Application No: P/88/22/DOC

Site Address: Land North of Sefter Road & 80 Rose Green Road Pagham

Description of Works: Approval of details reserved by condition imposed under P/134/16/OUT relating to conditions 10-surface water drainage, 12-maintenance and management of surface water drainage system, 14-foul drainage system, 16-external lighting, 17-Construction Management Plan, 22-setting out when roads, footpaths, cycleways and emergency routes are to be construction, 26-street lighting and 28 (part)-energy conservation and renewable energy.

North of Sefter Road, Pagham – P/88/22/DOC Comments Tracker				Initial Issue Date: 12-10-2022 Issue Date: - Revision 1.0	
	ADC Drainage Comments 11-10-22	Applicants Response			
	Initial/Planning:

Network Design Table for Surface Network 2

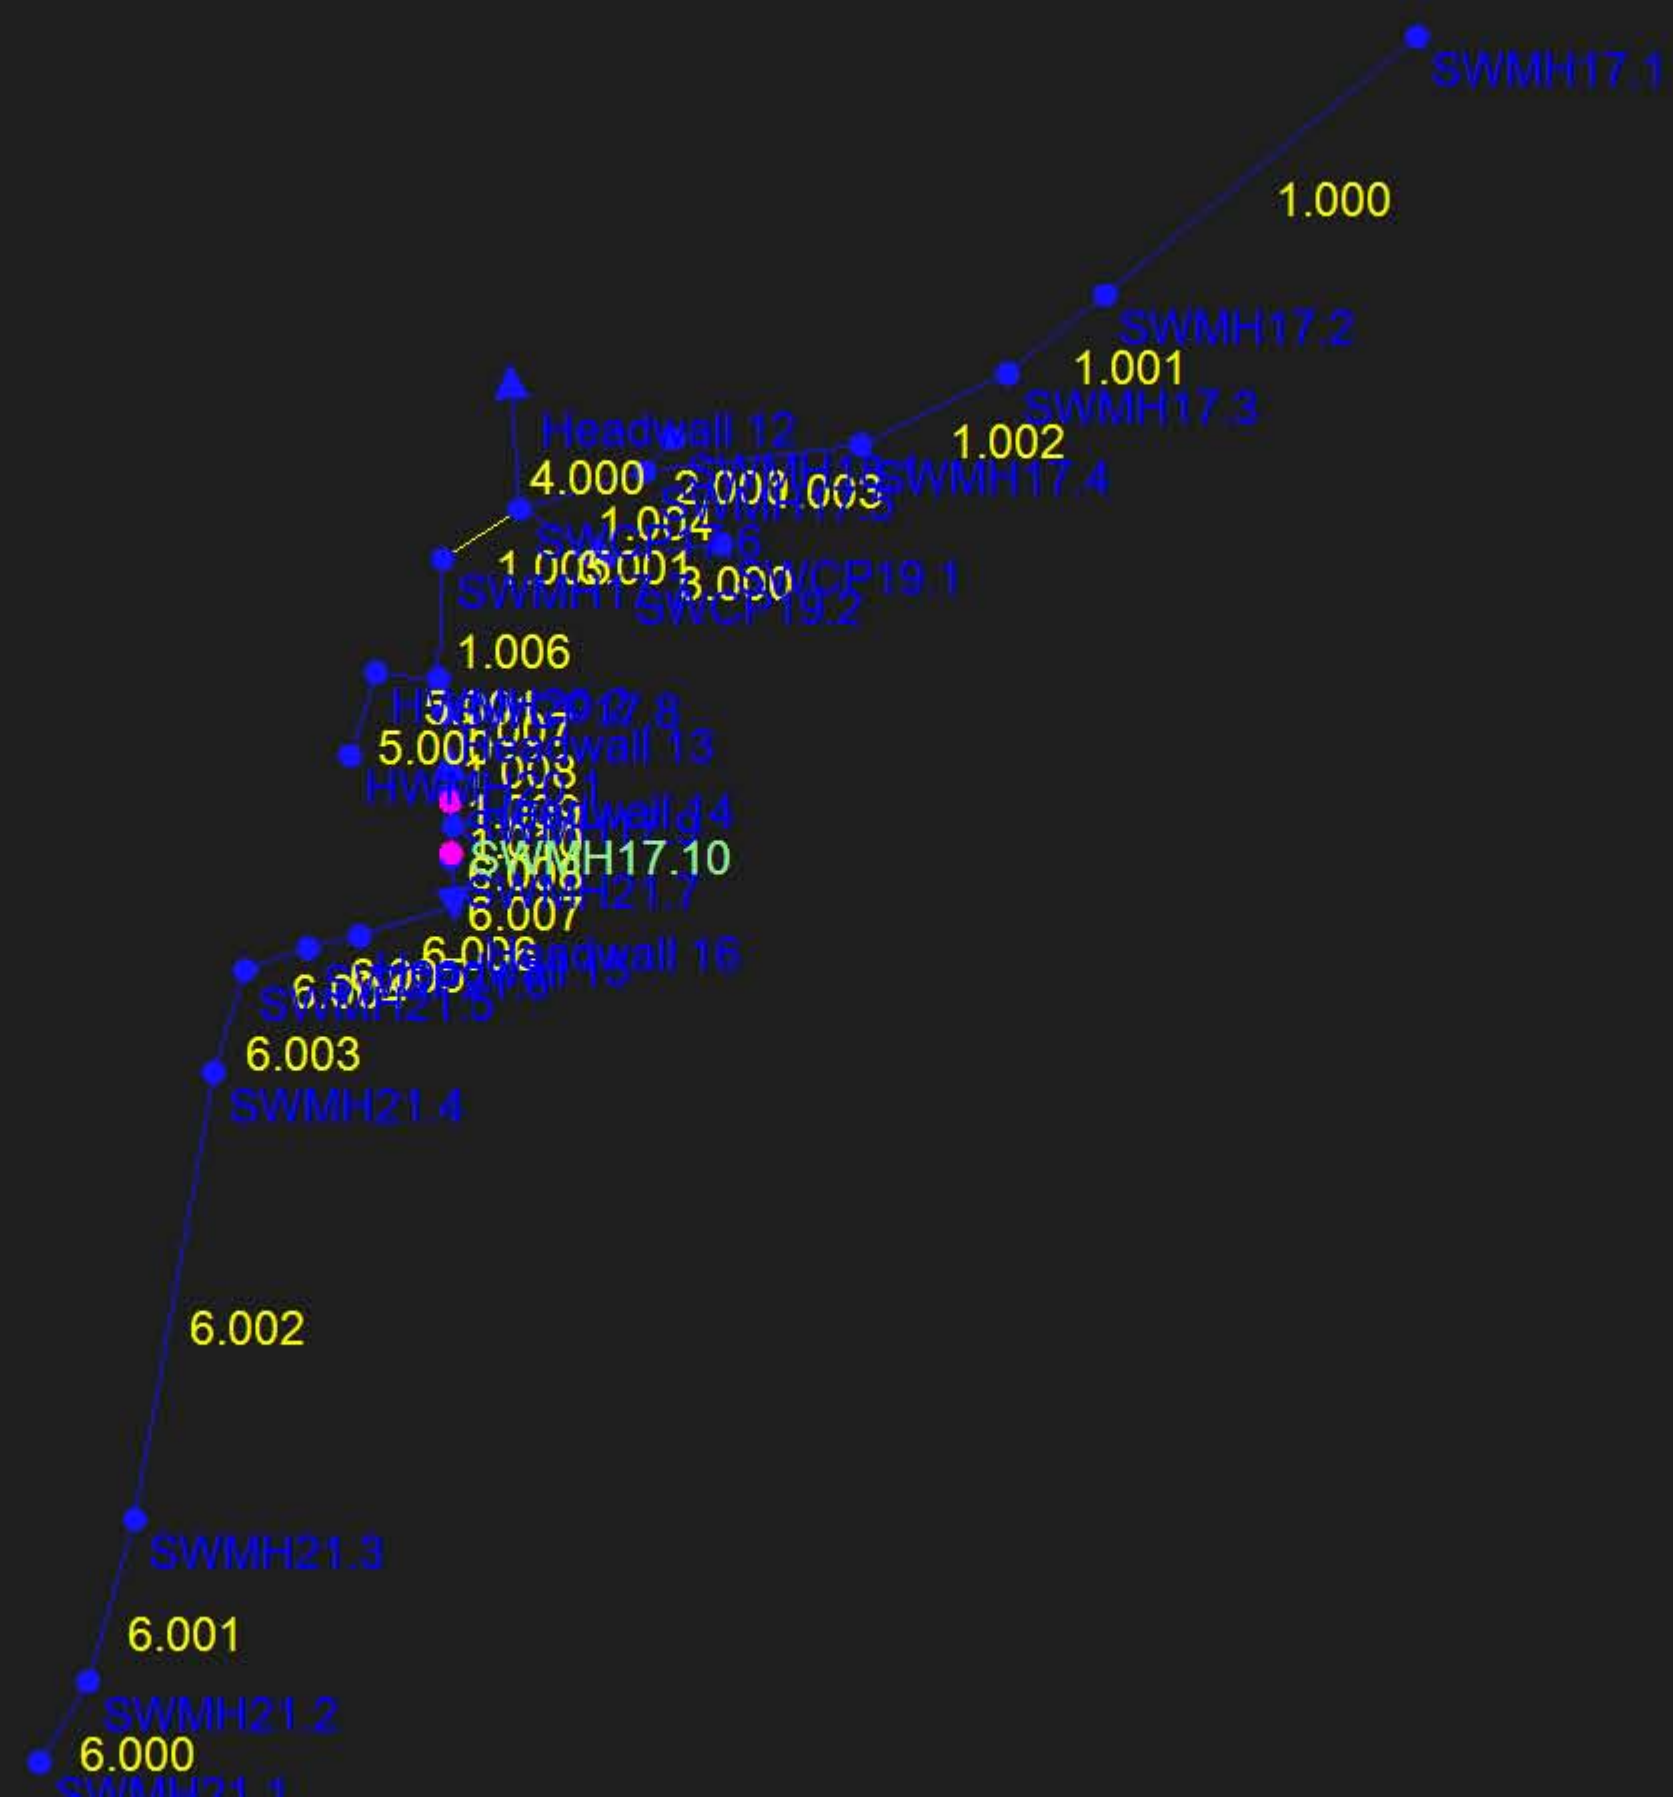
43.	Network 1 PN1.016 has a self-cleansing velocity of 0.46m/s; this must comply to a minimum of 0.75m/s BRegs or 1.0m/s DCG.				
44.	Network 2 PN3.000/PN1.005/PN1.008 have reduced self-cleansing velocity; this must comply to a minimum of 0.75m/s BRegs or 1.0m/s DCG.

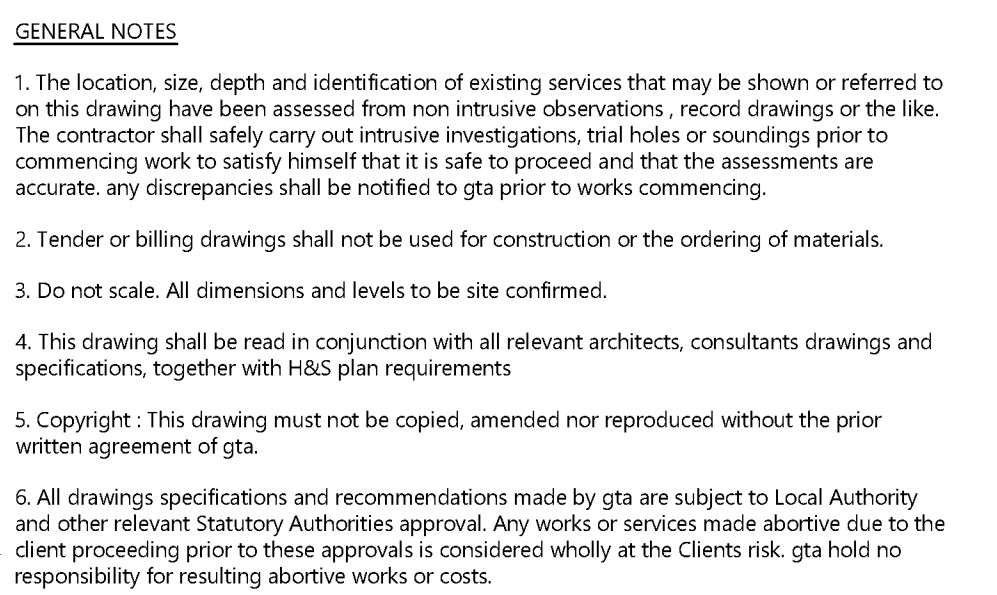
10.	With reference to drawing 1602/P6 the buffer in between the diverted watercourse and SW basin 5 does not comply with the minimum 3.0m.

Typical Surface Water Attenuation Tank

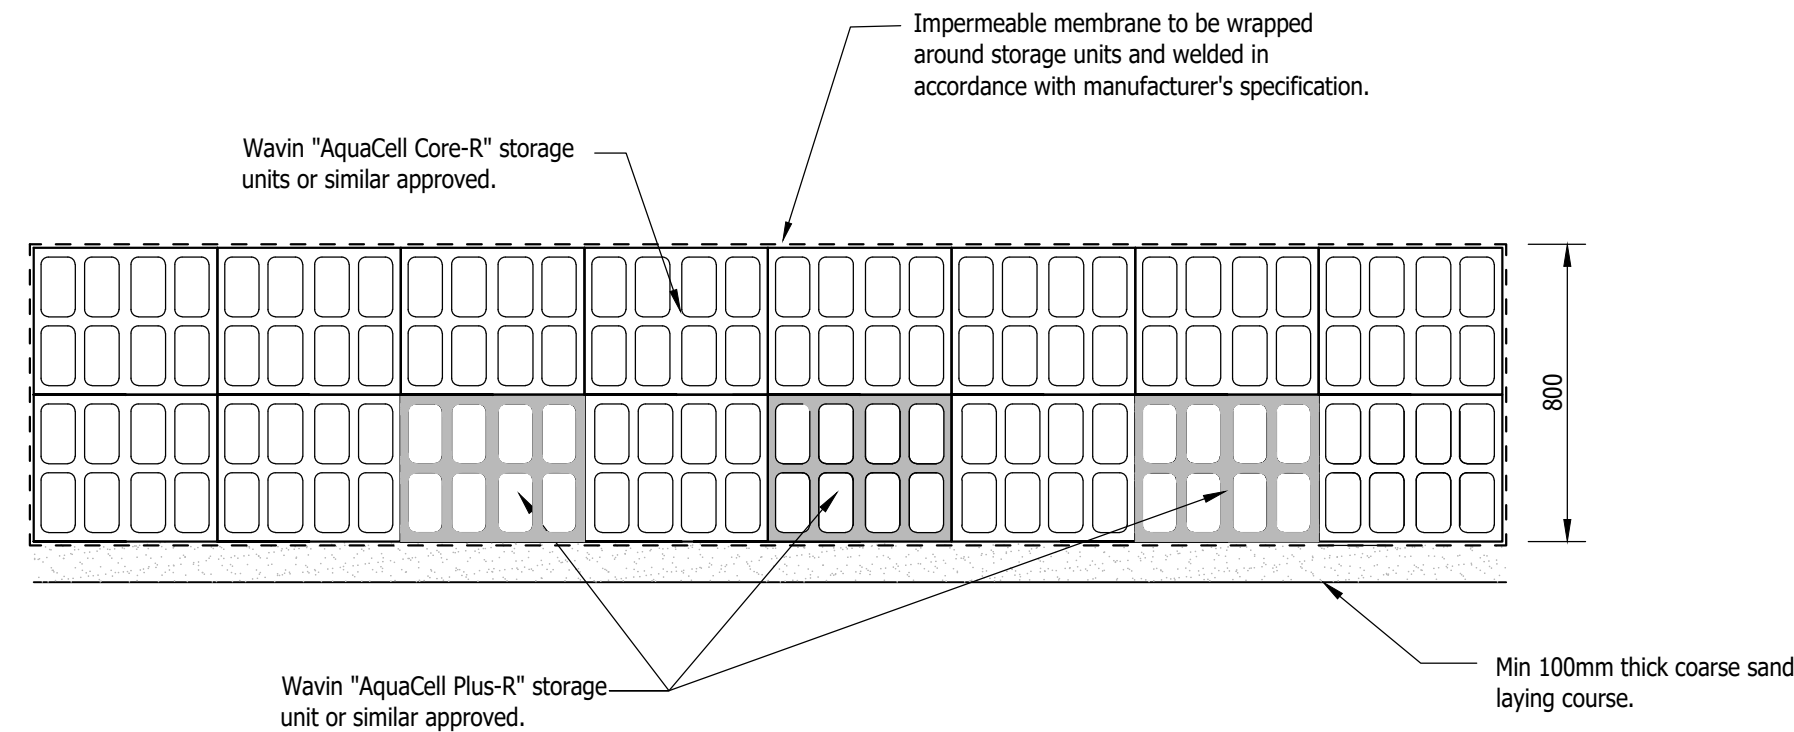
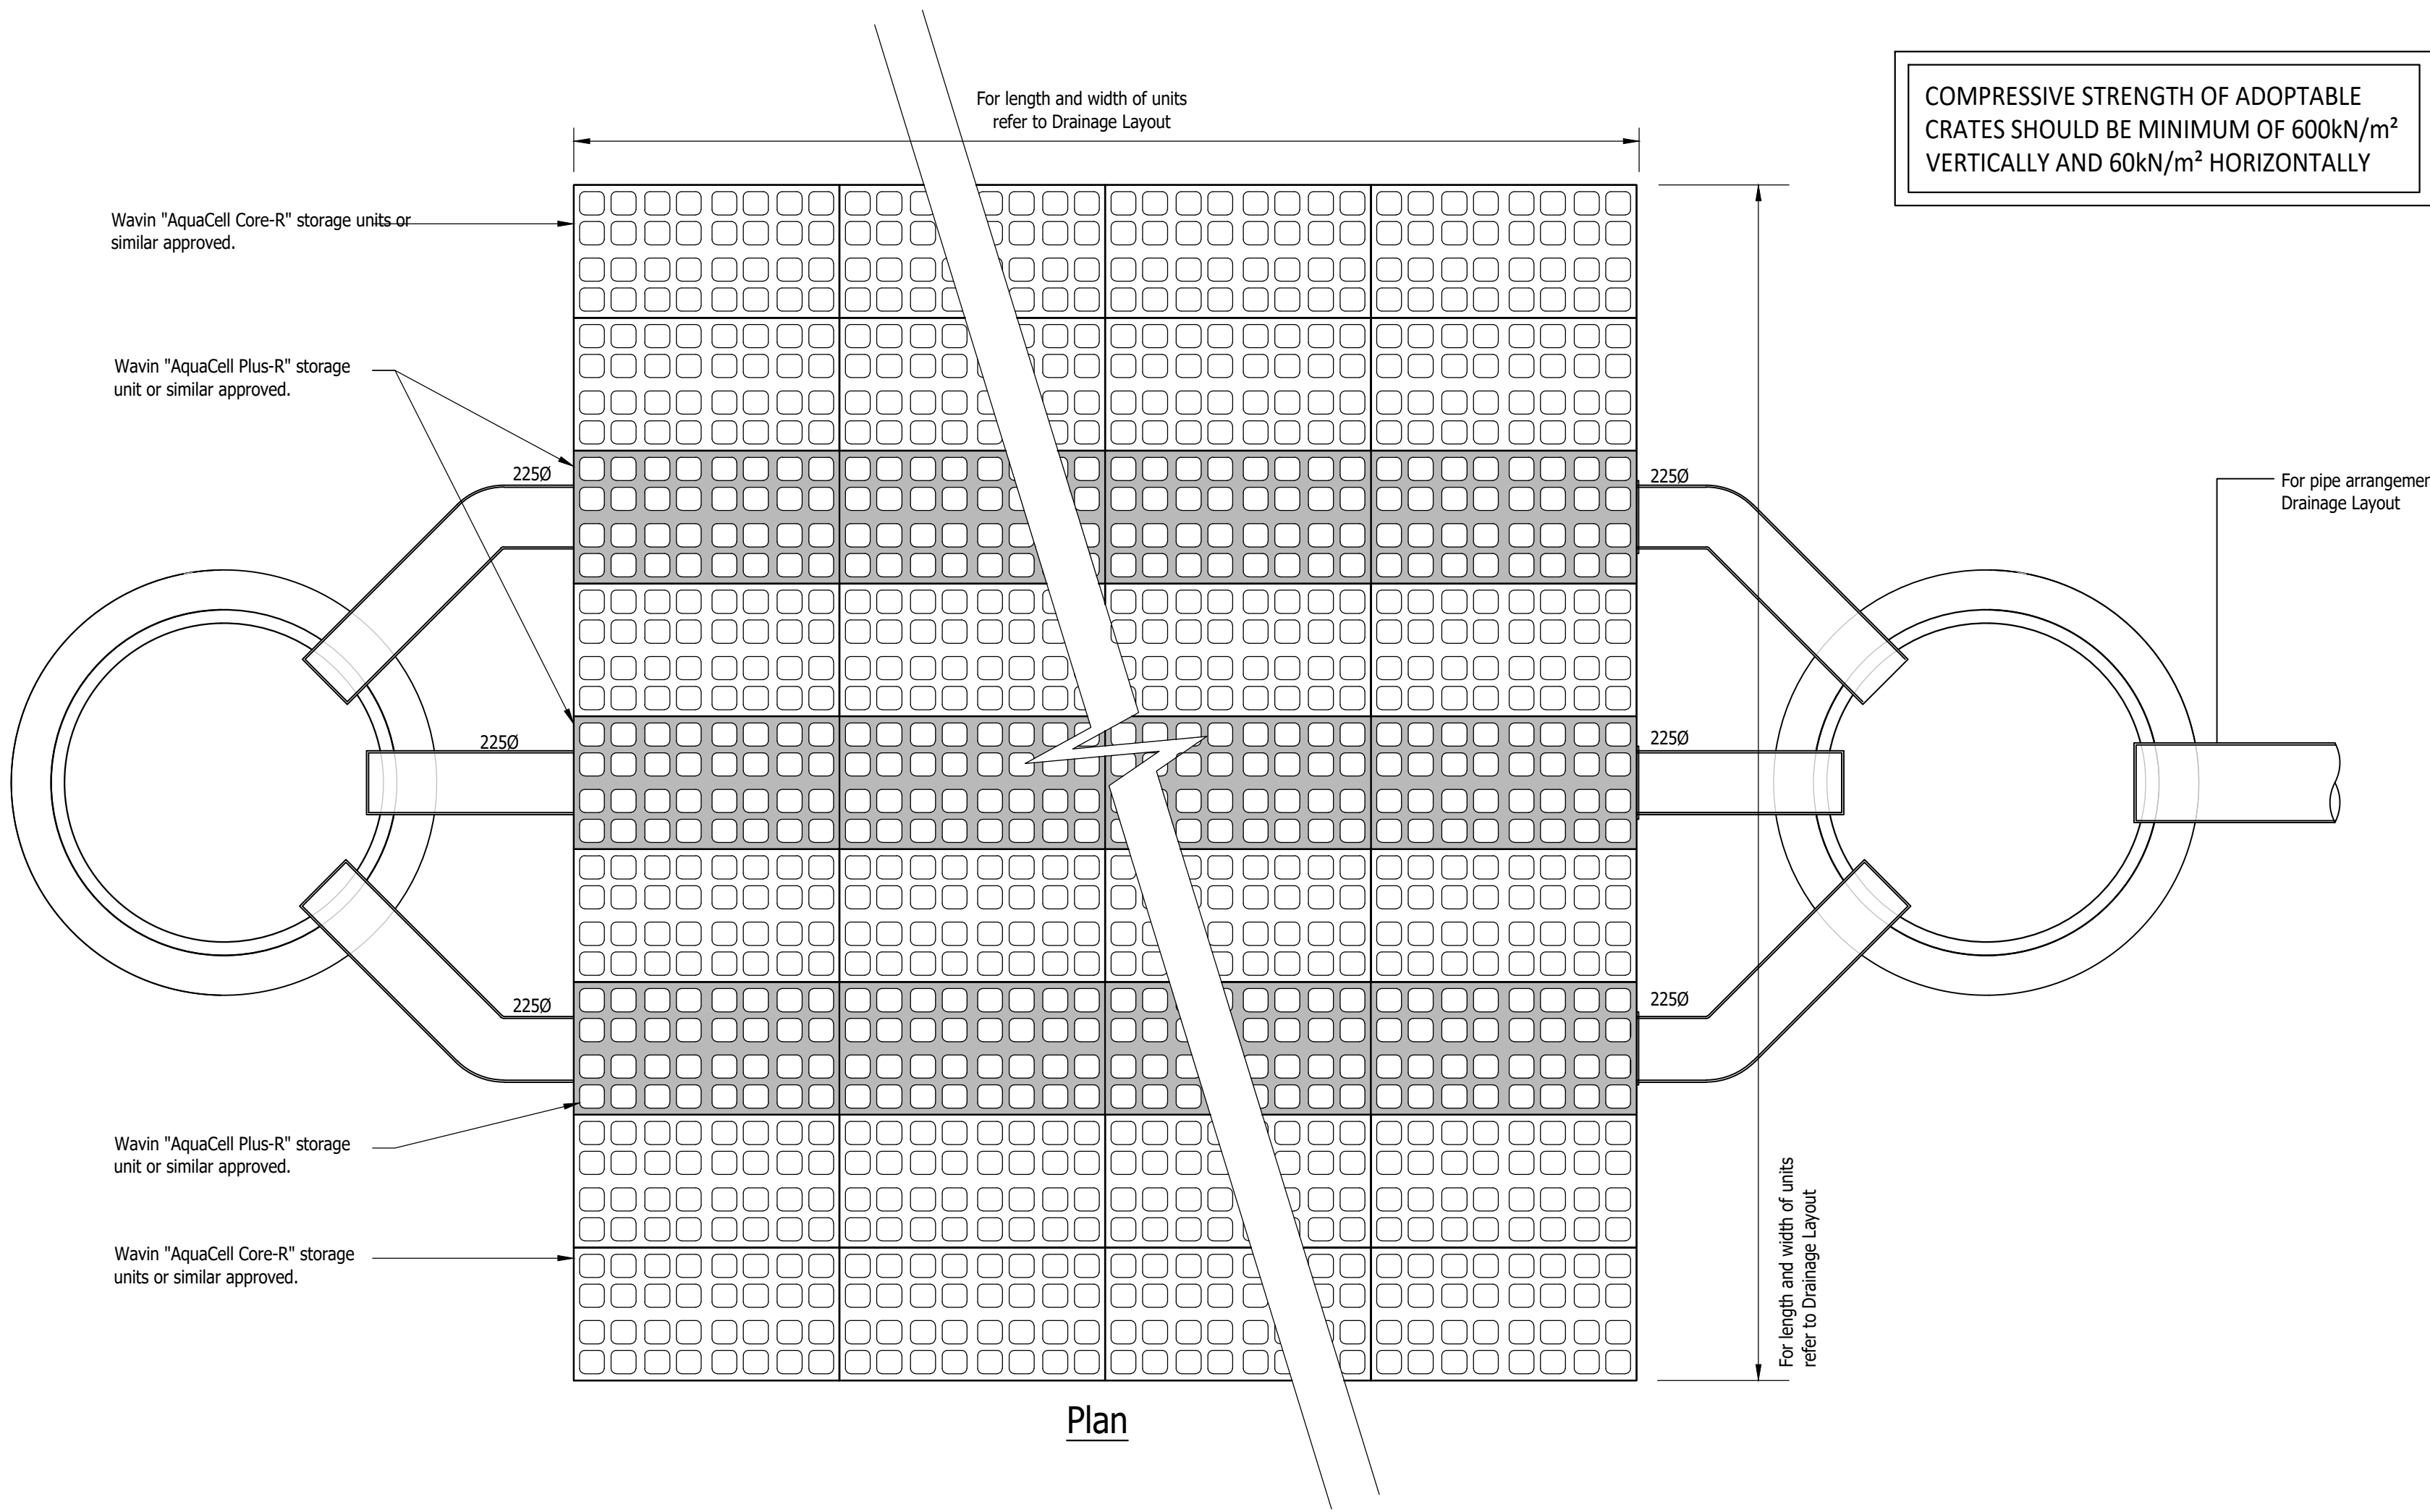
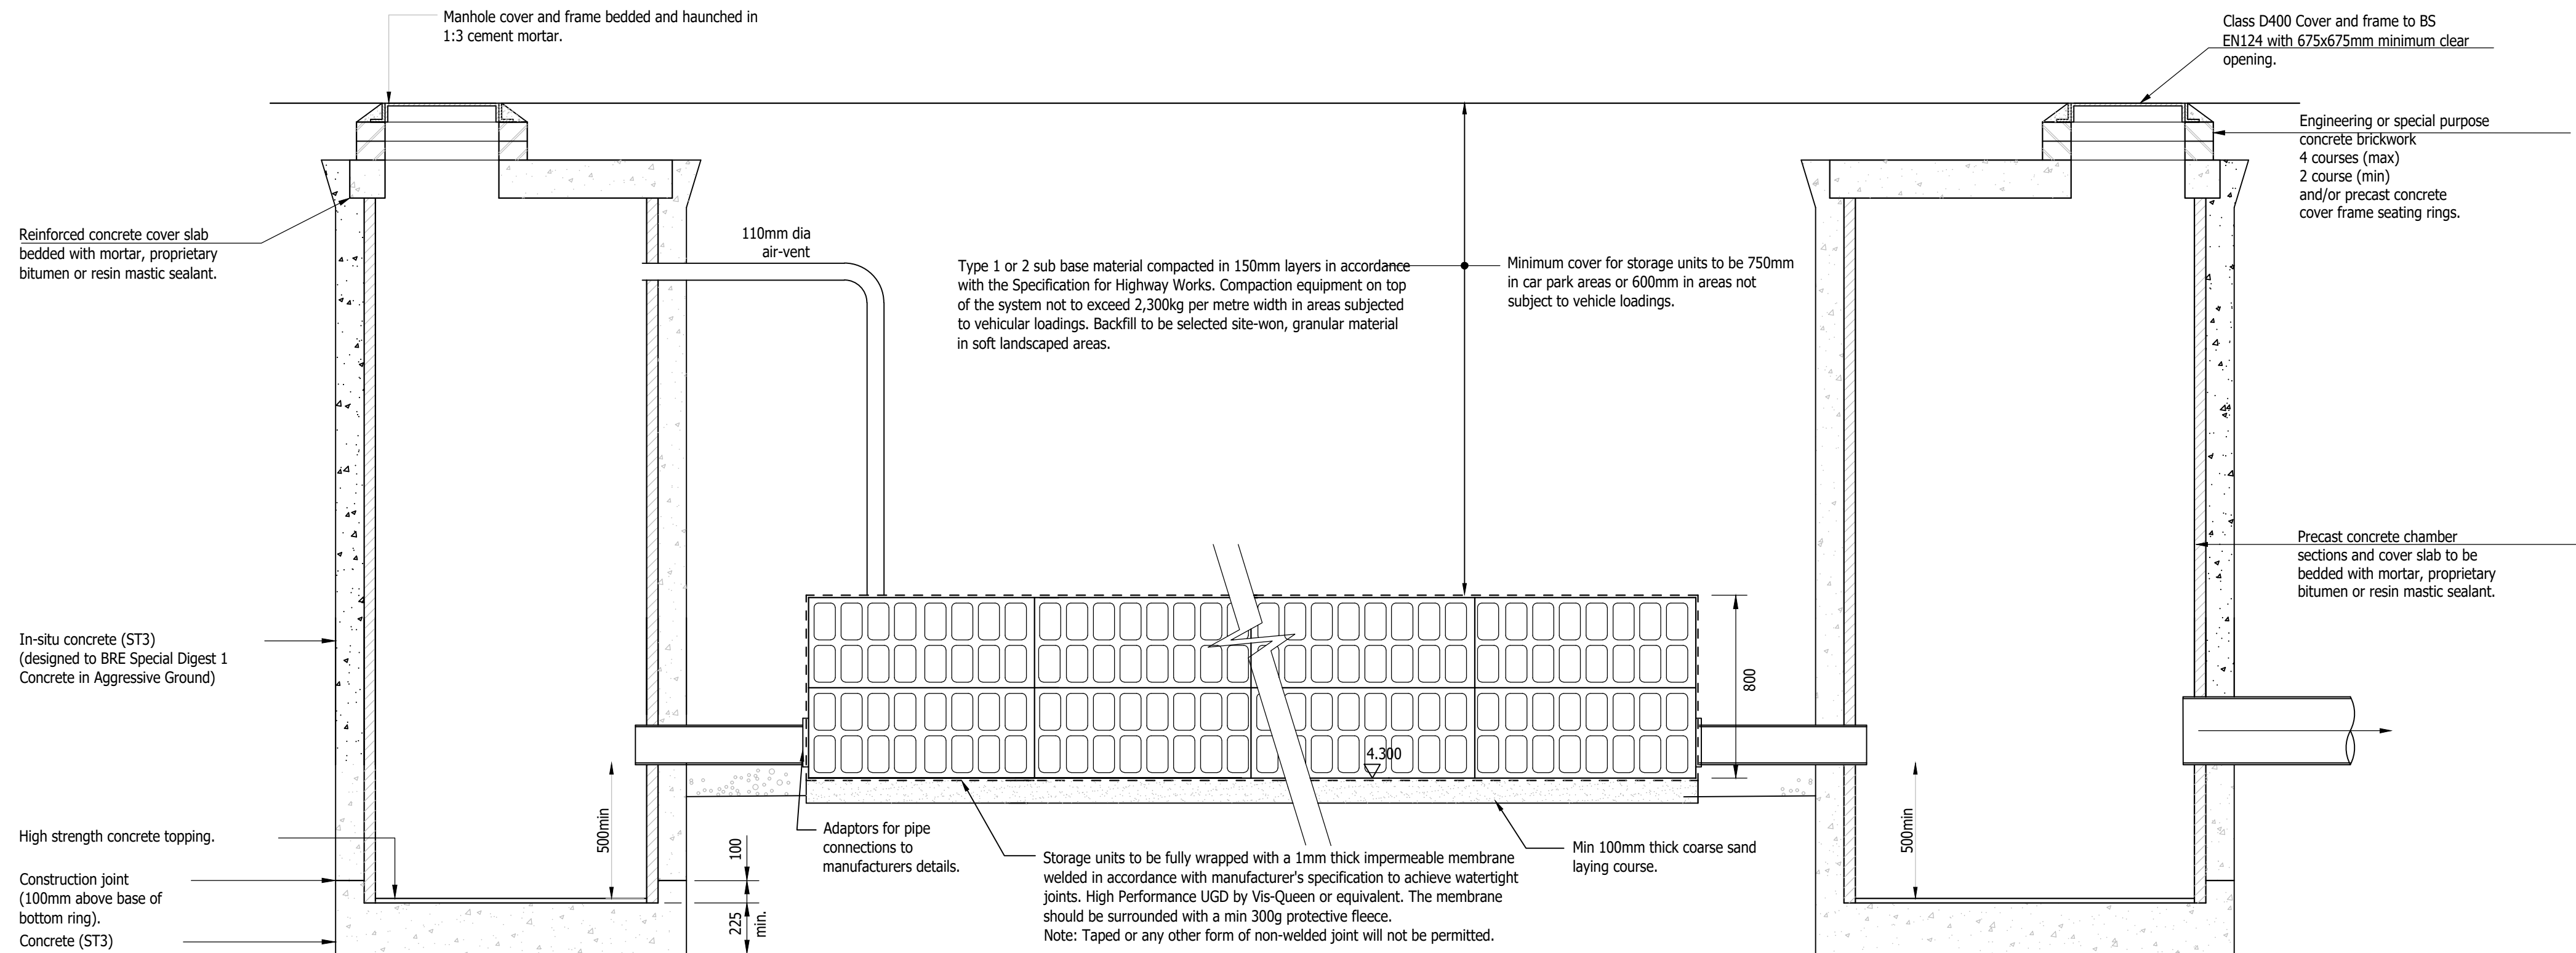
26.	Attenuation tank 1 illustrates triple 225mm manifold. These pipes do not provide the same conveyance capability of one 600mm diameter pipe and may affect 1D modelling results.
